2023/0237

Erection of storage building

Unit 2, Oxspring Wire Mills, Sheffield Road, Oxspring, Sheffield, S36 8YW

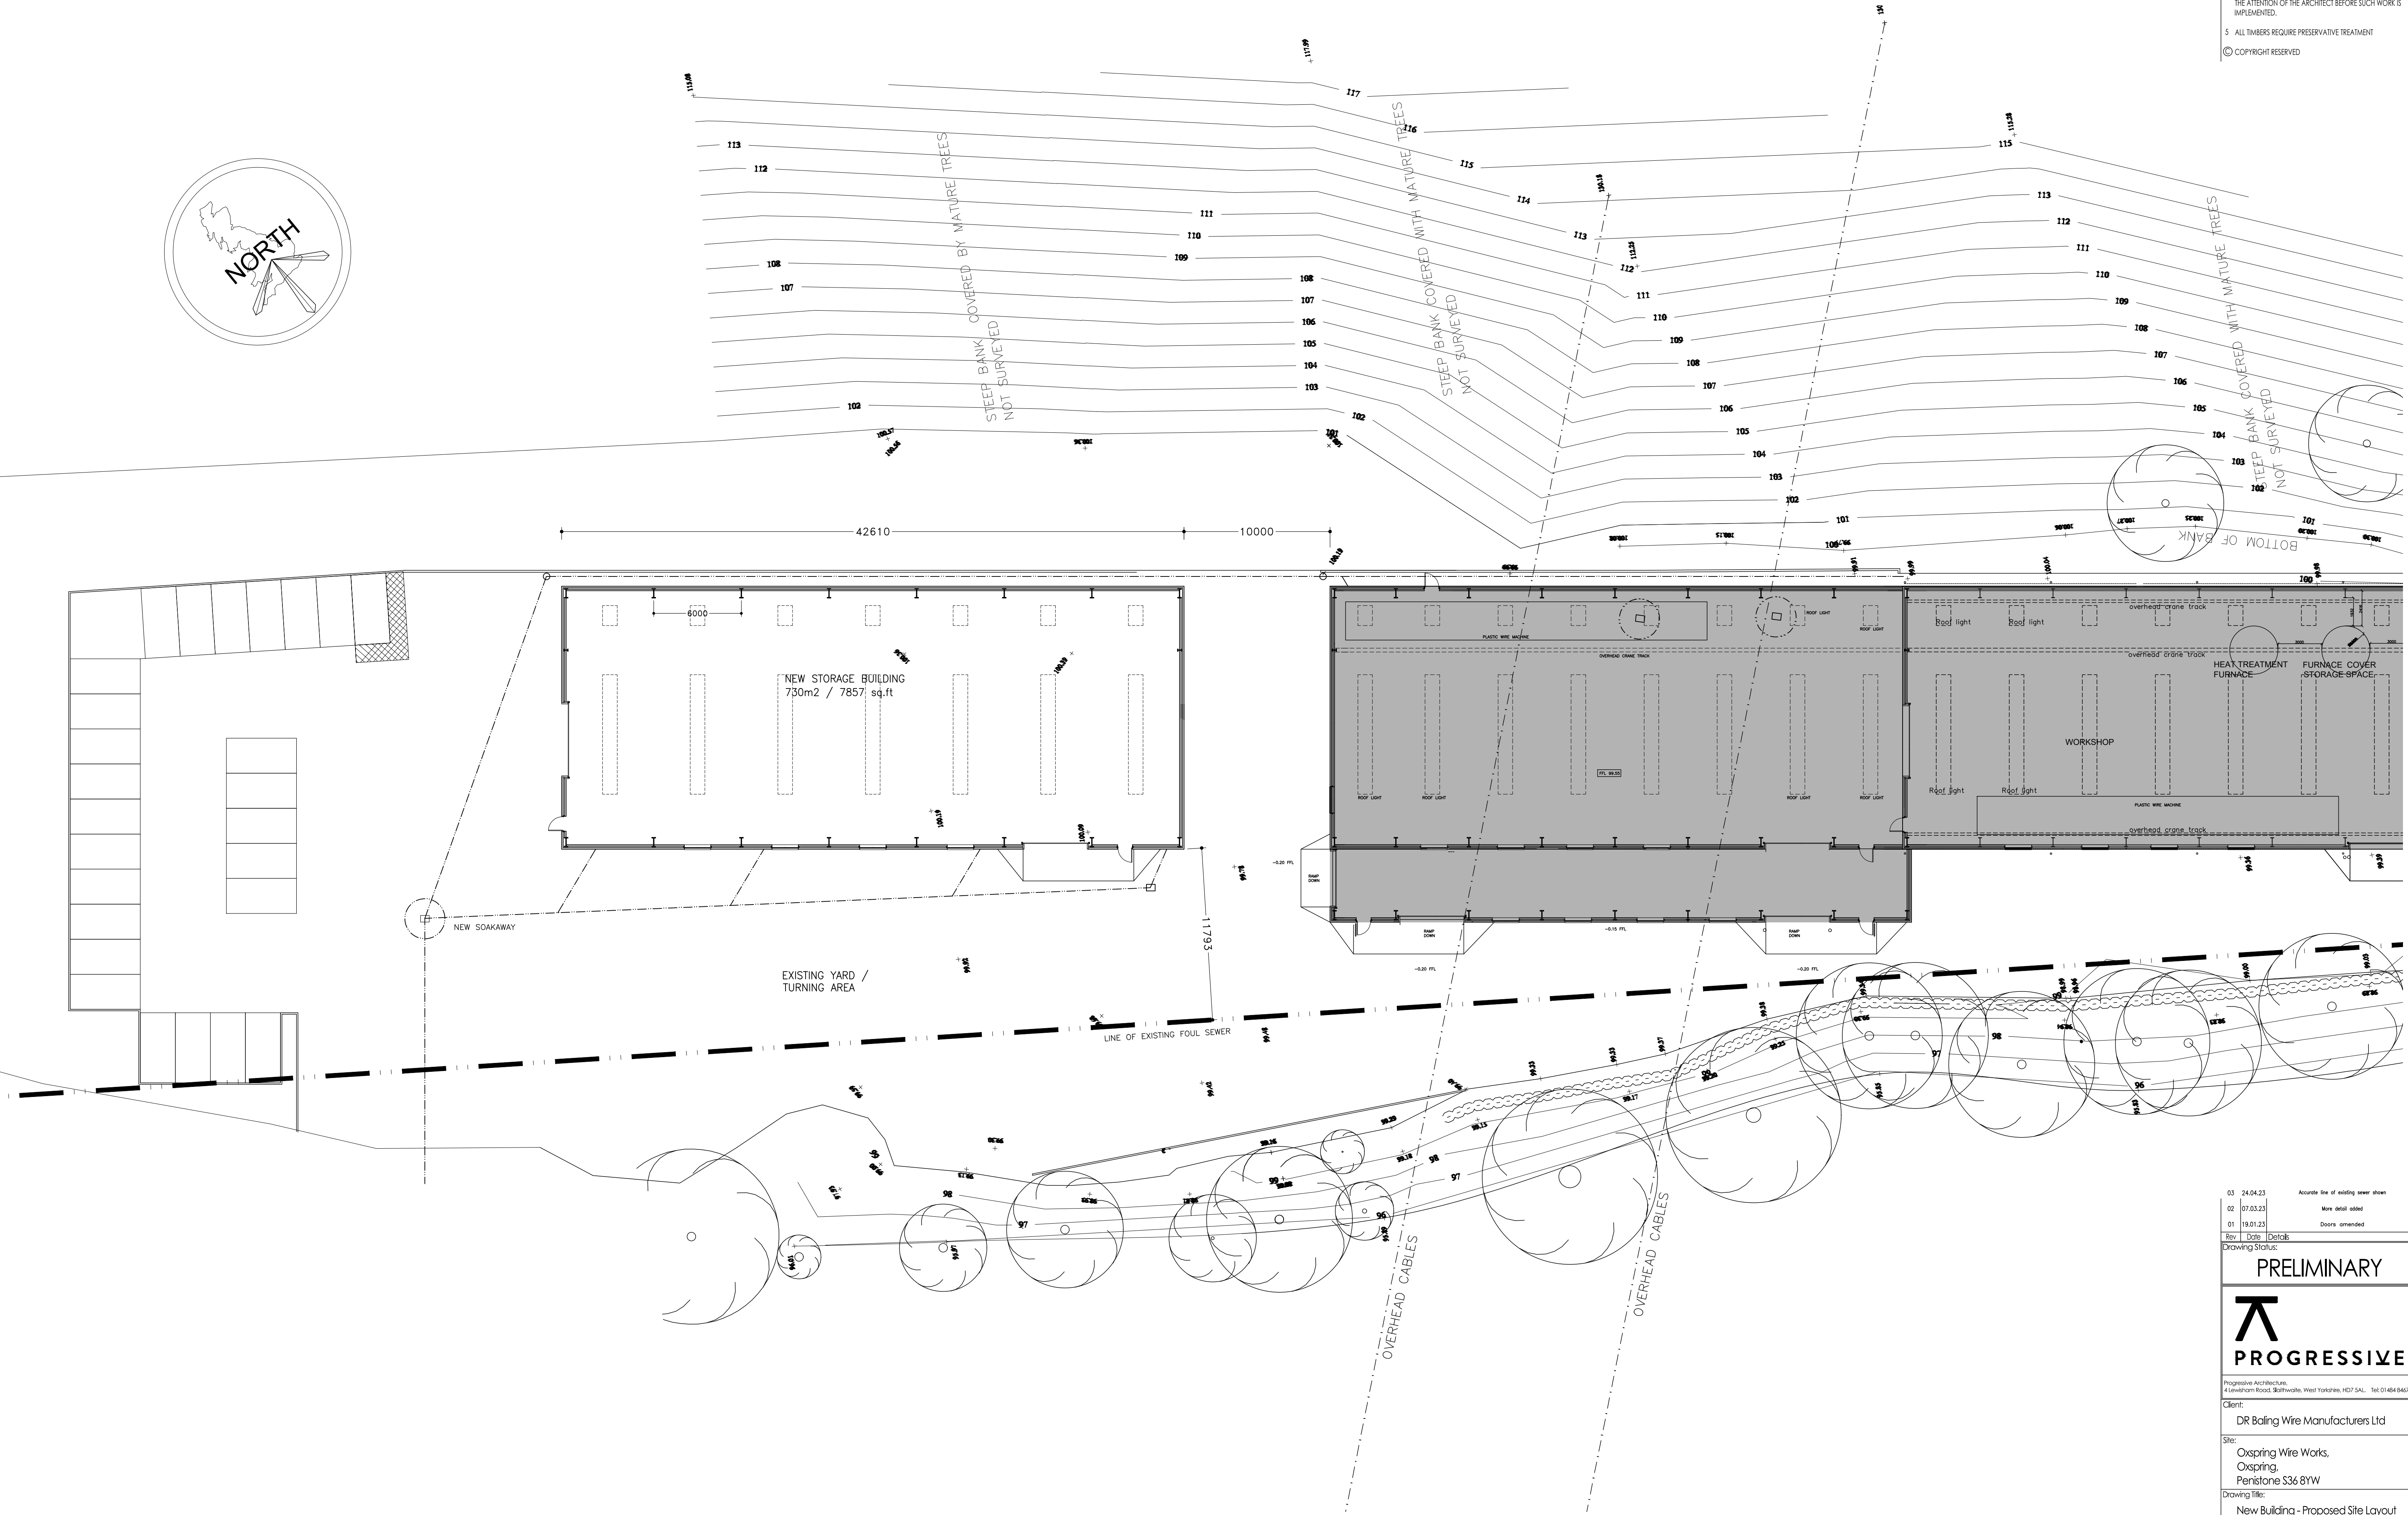
'Yorkshire Water has no objection in principle to the layout submitted on drawing 'New Buildings - Proposed Site Layout' P1153 10 03 (revision 03) dated 24/04/23 that has been prepared by Progressive, namely: - a.) The line of the existing sewer 600mm sewer as plotted through site survey - there is adequate stand-off distance from the public sewer to the proposed buildings. 2.) It is noted from the submitted planning application that surface water is proposed to be drained to soakaway - Yorkshire Water fully endorse this means of surface water disposal.'
